LEGACY CHURCH - GREEN MOUNTAIN FALLS, CO DEVELOPMENT PLAN

COVER SHEET
SHEET 1 OF 13

## DEVELOPMENT PLAN

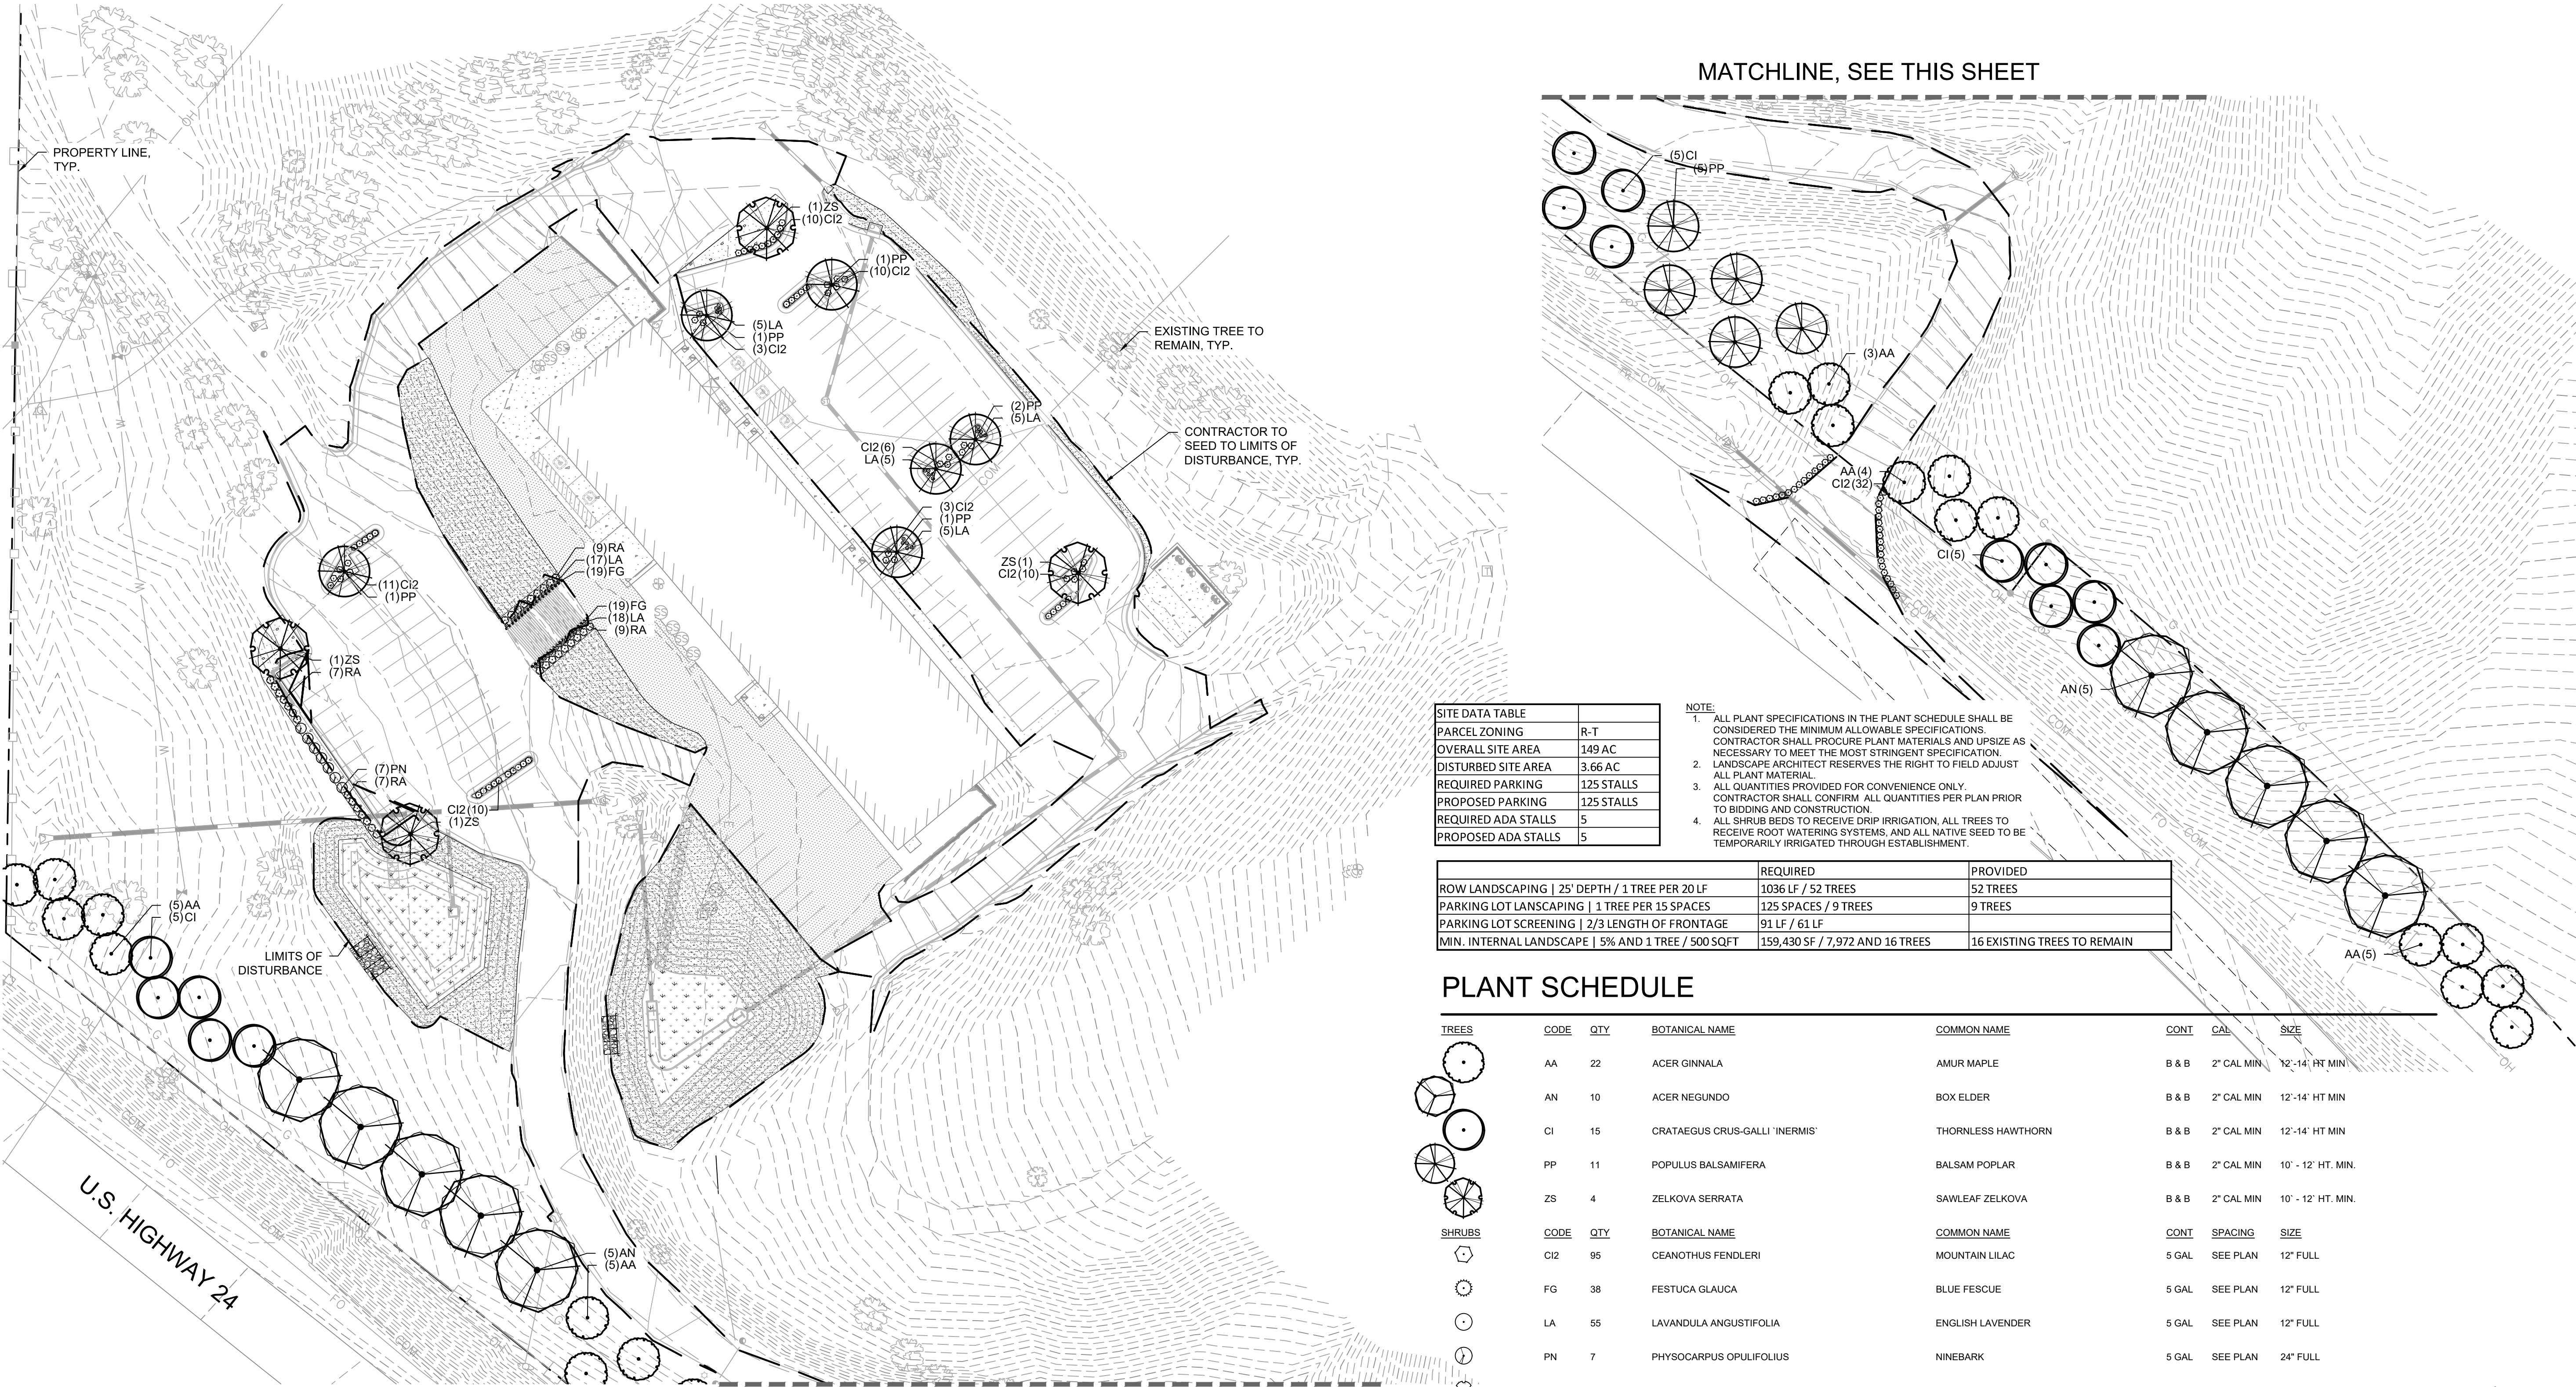
The letter of intent and the site plan on sheet 3 indicates 423 seats. Please revise accordingly.

Review 1 comment:
 Parking information does not match what is shown on the previous page. Revise accordingly.

Review 2: Unresolved. The building capacity also does not match the previous page. Please revise so that all the information is matching.
